29 Louisa Road

9<sup>th</sup> December 2010

Attention; Shivesh Singh, Re Application # MP09\_0016

STEPHEN STREET ELEVATION

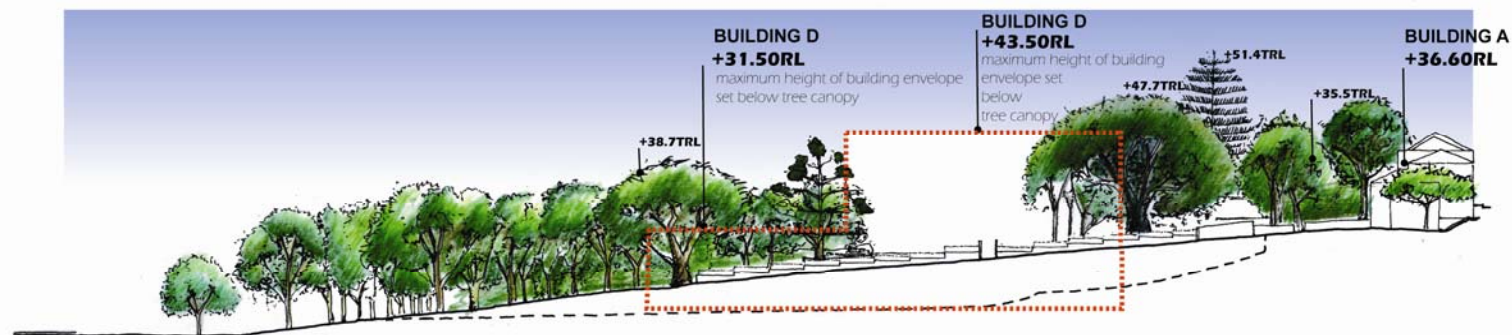
Stephens Street is not in my view designed for heavy or constant traffic movement nor does it have the width to accommodate both the cars parked on both sides of the street and two way traffic movements. Car parking is very limited and the removal of any spaces in the street will have detrimental effects on the wellbeing of the local community.

Insufficient space exists to accommodate vehicles turning into and from this site. I support the use of Brown Street as the service point for the aged care facility. Garbage pickup, amongst other services is designated as being serviced from Brown street. I again suggest that all services be directed to the Brown Street area. Stephens Street is not suitable for regular commercial traffic.

Noise from the currently planned large bank of Air Conditioners is positioned directly opposite 40 Stephens Street. With 24 hour per day running, the noise will be unacceptable to residents and I request your urgent consideration to the repositioning of these.
